From: Matthew Saunders <ecclesiastical@hbap.org.uk>
Sent: 19 August 2026 15:55
To: Planning
Subject: 3/2026/0421, Chipping Congregational Church PR3 2QH For attn MAYA CULLEN
Attachments: 26 0421 Email Consultation.pdf

The application is for - Listed Building Consent for proposed new stair and first floor within a portion of the main hall, insertion of glazing in wall to create viewing gallery and insertion of secondary glazing to three existing windows.

Glazed viewing screen - validation detail

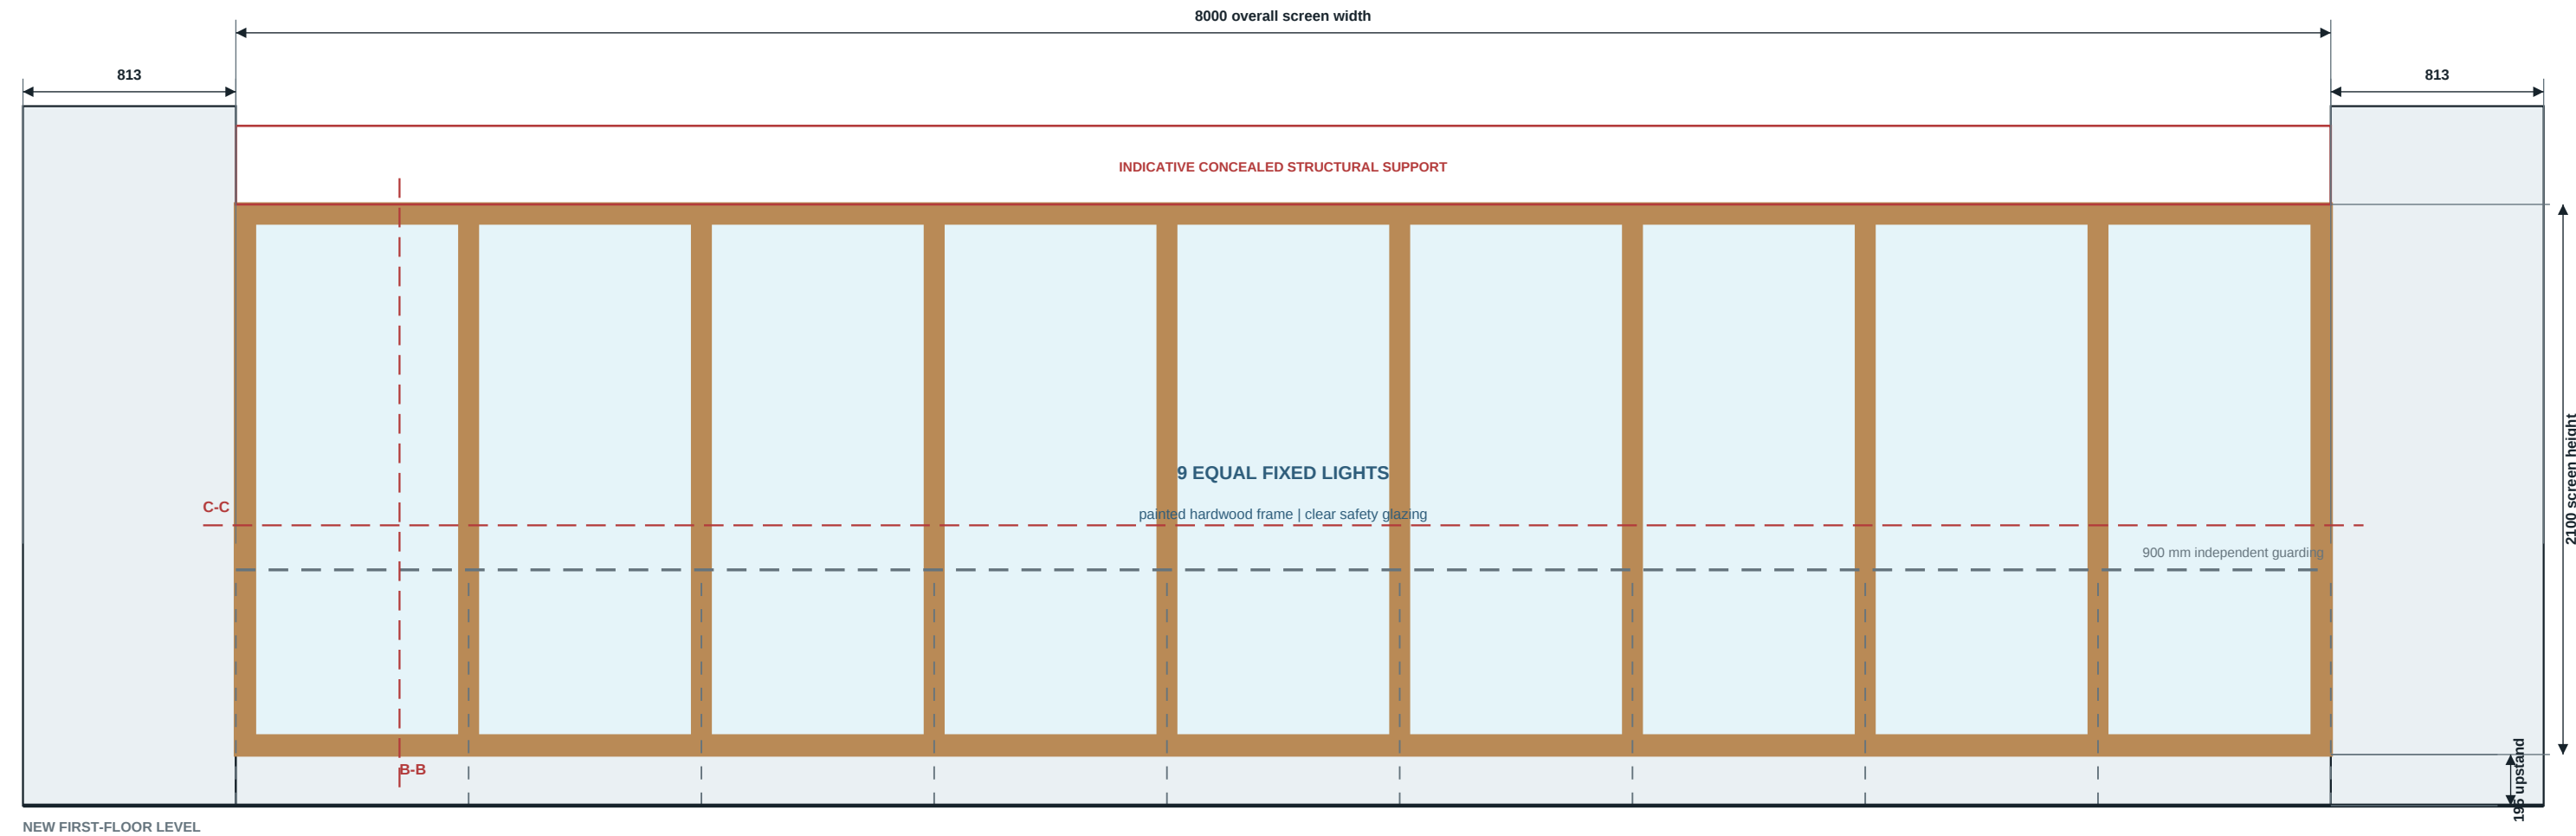
Are the applicants confident that the present shell can bear the extra loading of a gallery ? Is the gallery structure to be trenched into the shell at any point ? If so has an engineer been asked to give a view ?

Ground Floor Plan as Proposed

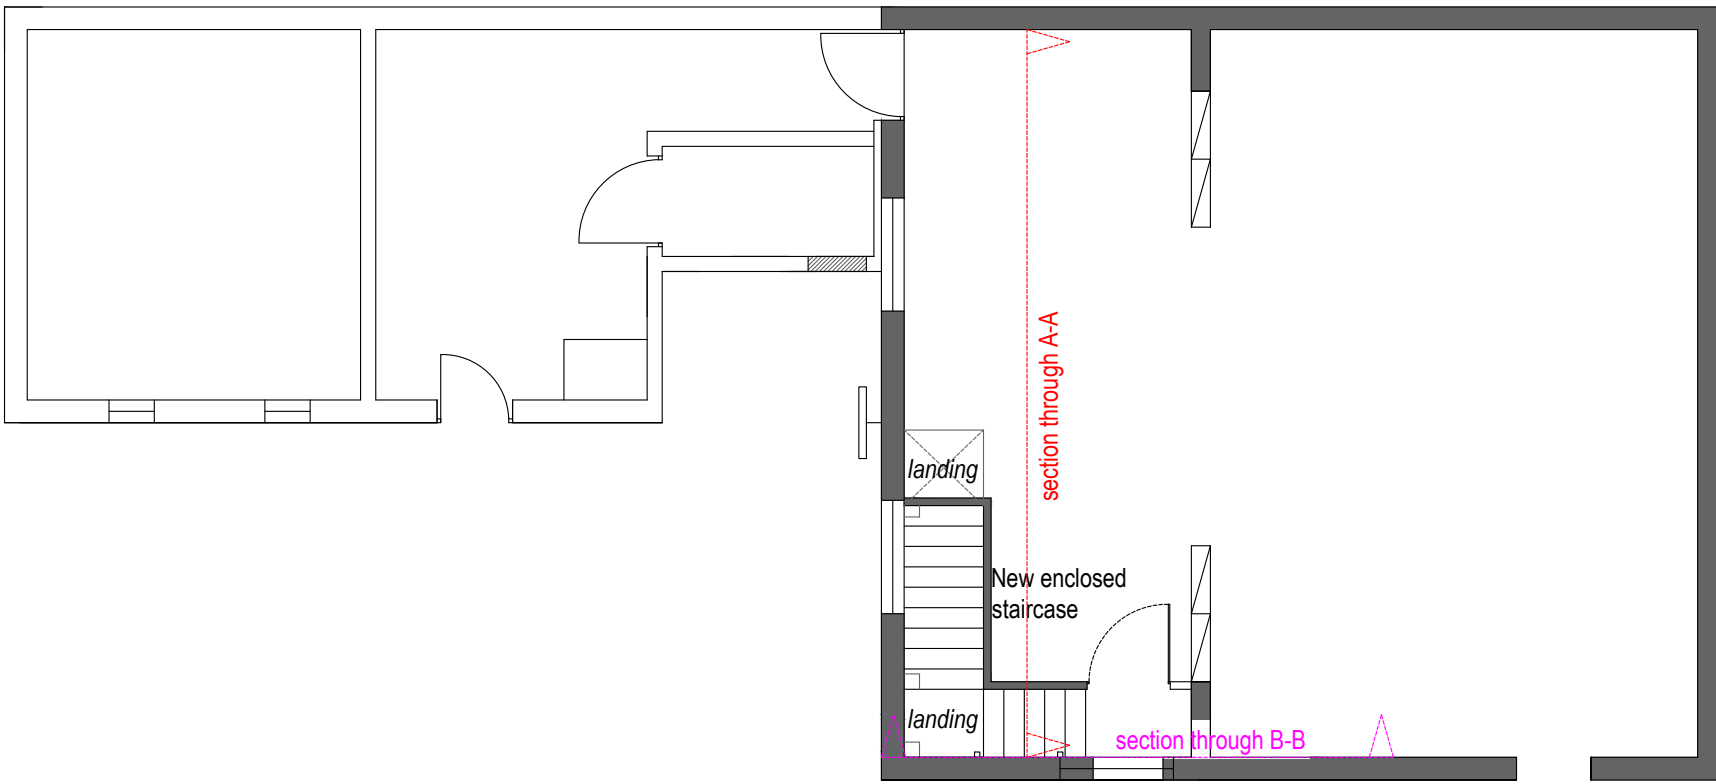
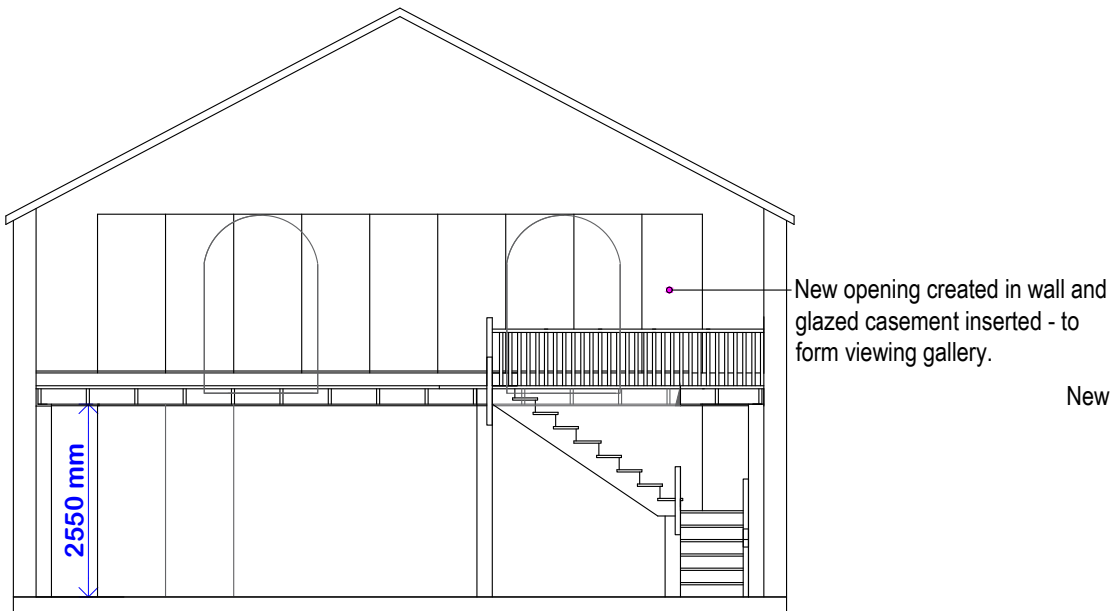
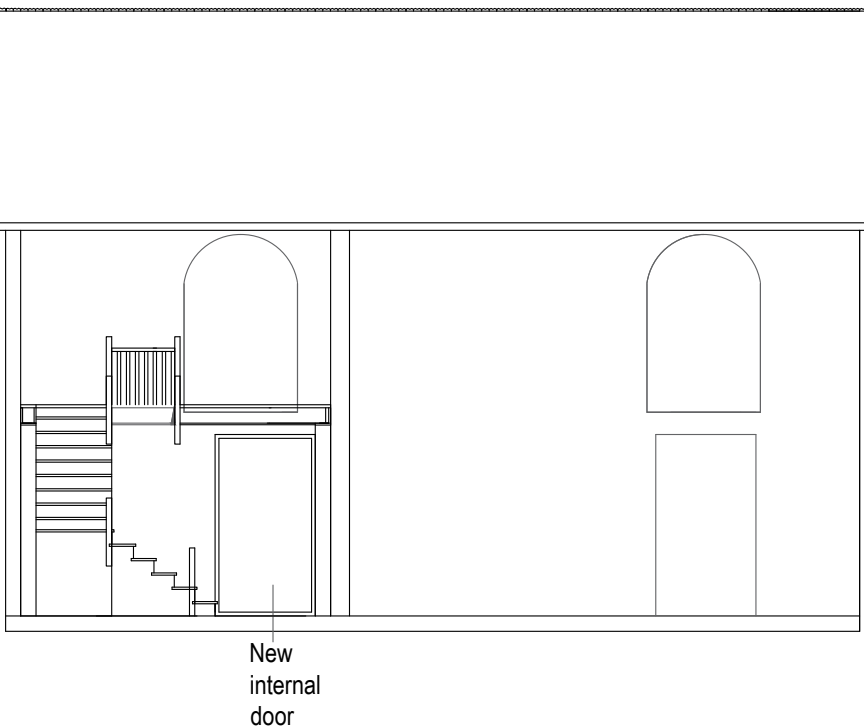
The fact that the gallery cuts across some of the windows is not a surprise but it would be good to know more about the appearance that will be manifested externally.
